The Examining Authority's questions from Issue Specific Hearing 4

Issued February 2020

Derby City Council – Answers to Questions

FIGURE 2.12C

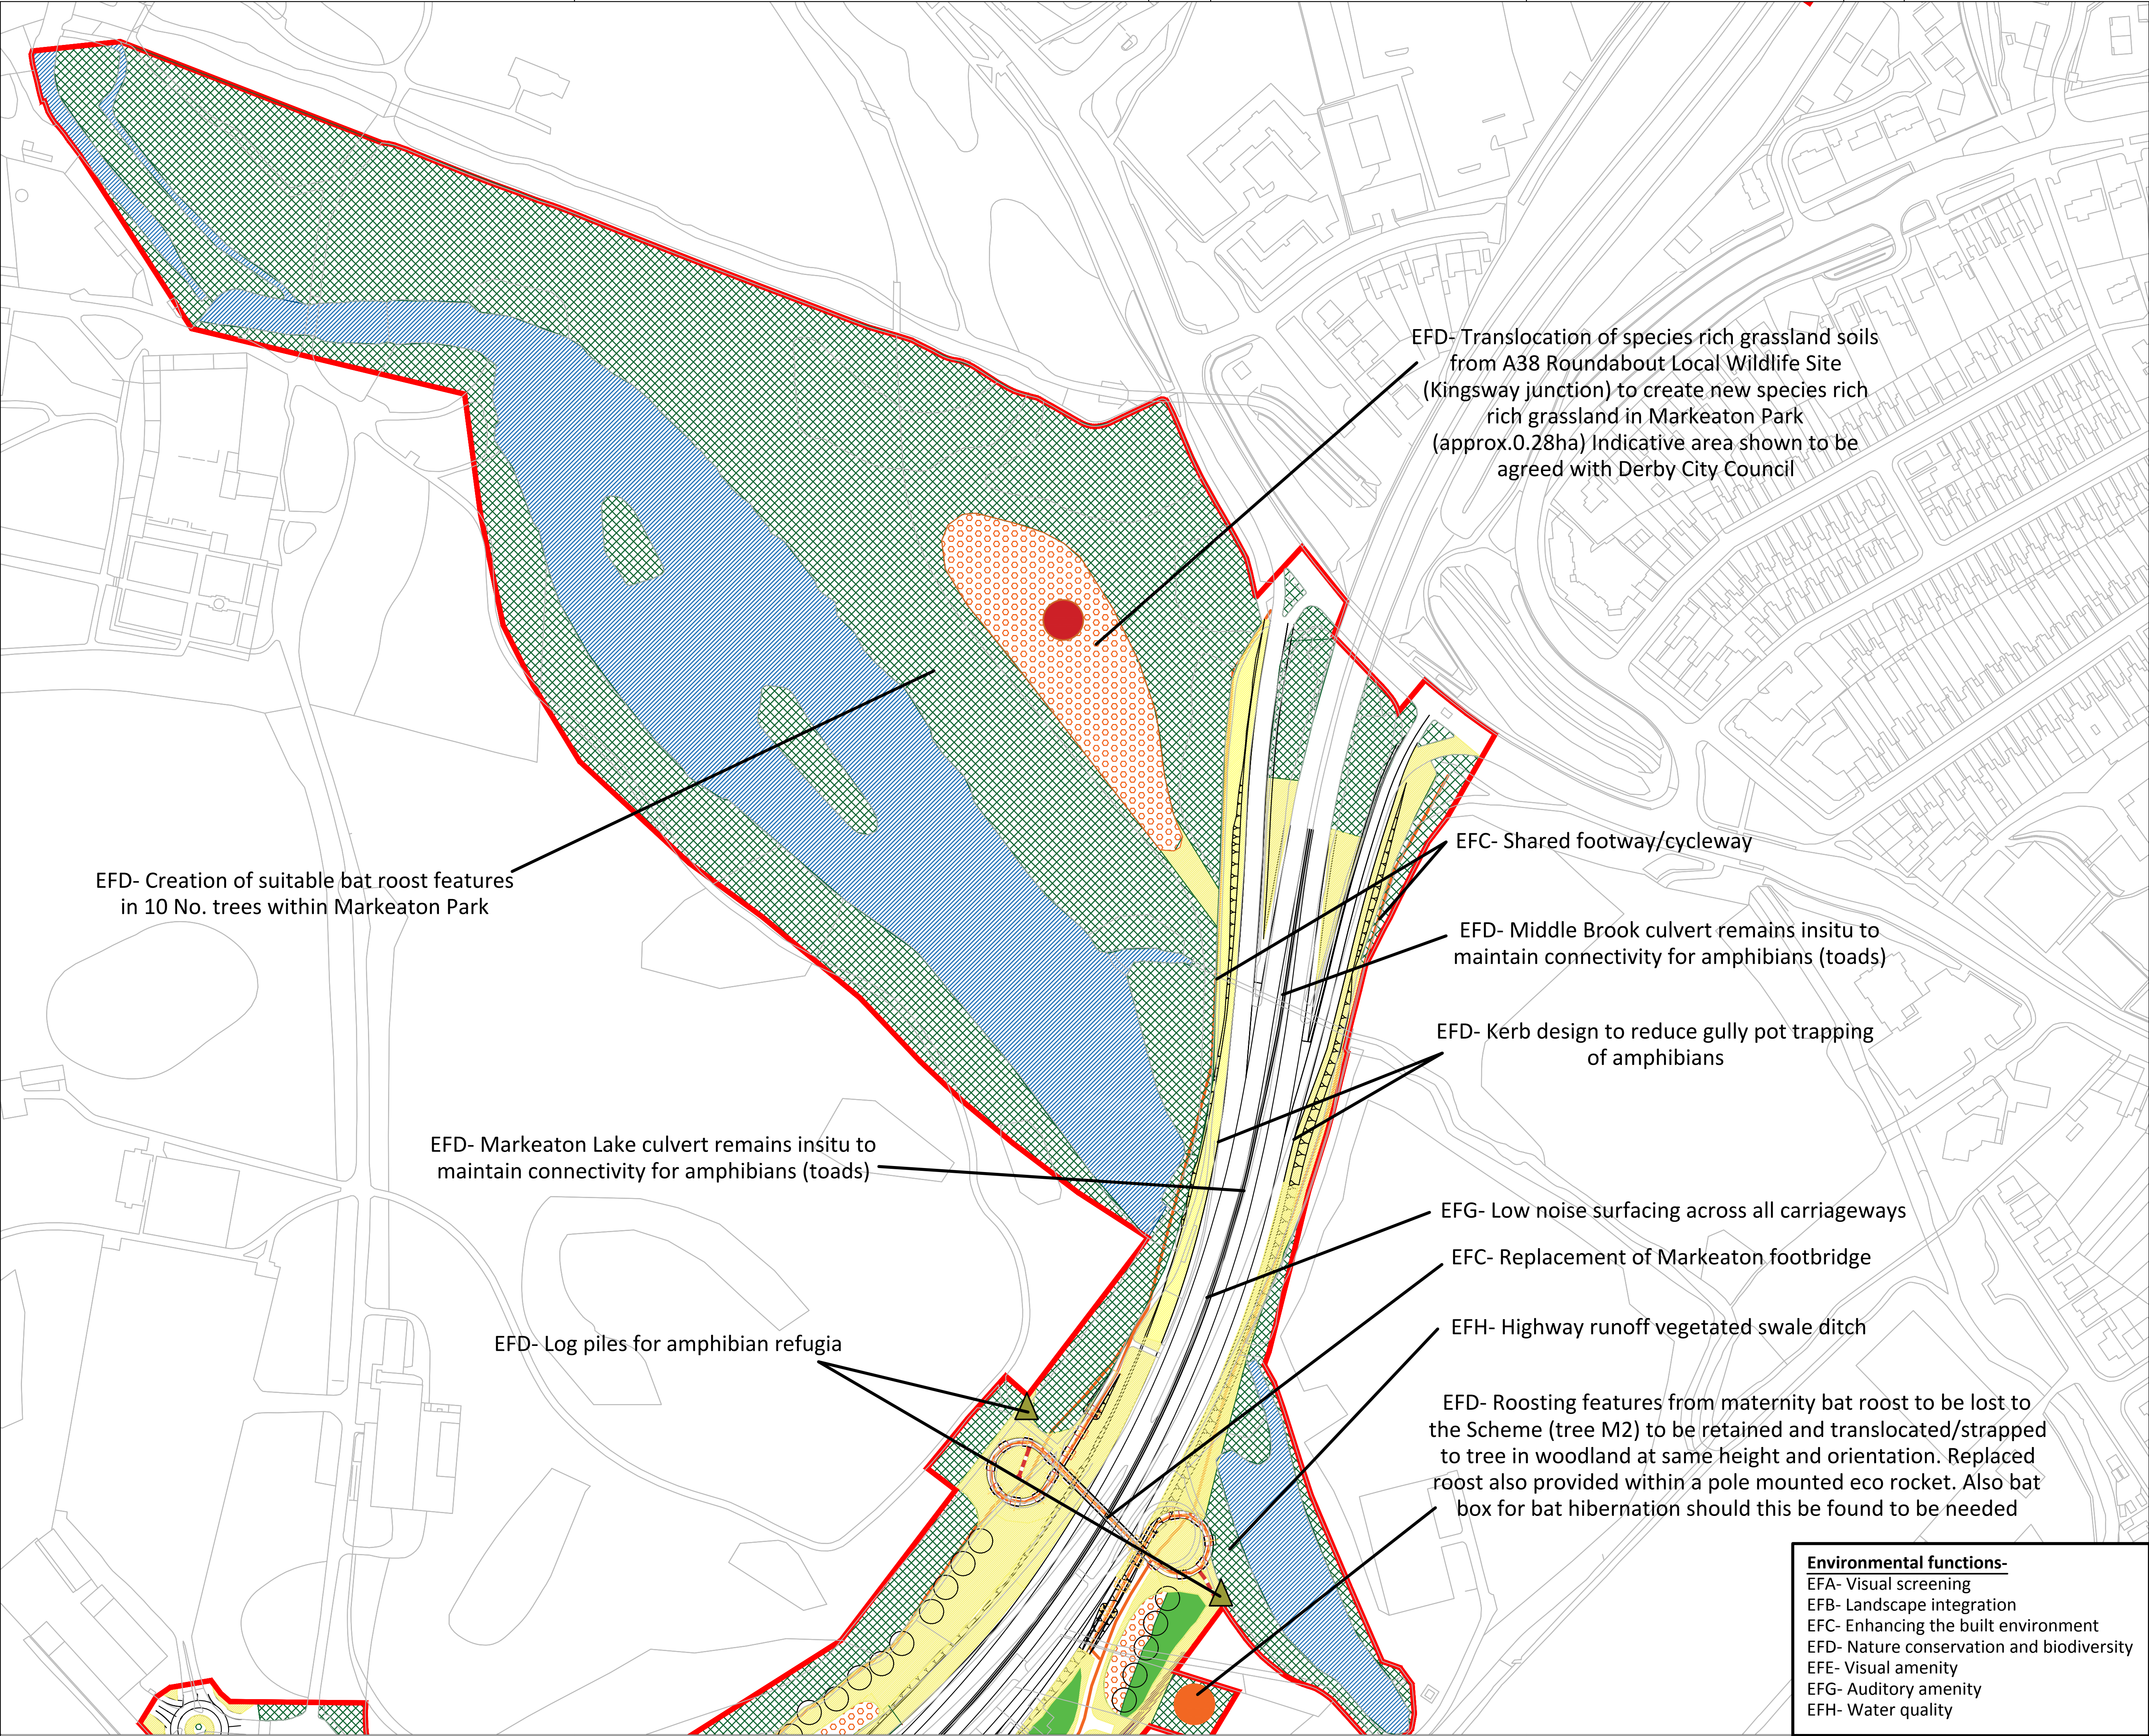
mitigation and how that would be secured.	minimal/nil disturbances to maintain the popularity and patronage of the park
Item 7	b) Whether the proposal would retain an adequate level of tree cover at the Markeaton junction. Whether adequate measures are in place to ensure retention of felled timber on the site as biodiversity mitigation.	DCiC is expecting a net gain in tree provision in the detailed plans

Item 10	a) Hydraulic modelling at the Markeaton junction. b) Flood compensation storage at the Little Eaton, Markeaton and Kingsway junctions.	DCiC can confirm acceptance of the Hydraulic modelling at the Markeaton junction DCiC also confirm the flood compensation storage is agreed
	d) Need for further information on discharge rates and volumes.	Detailed design will establish these rates and we would be looking for betterment where possible
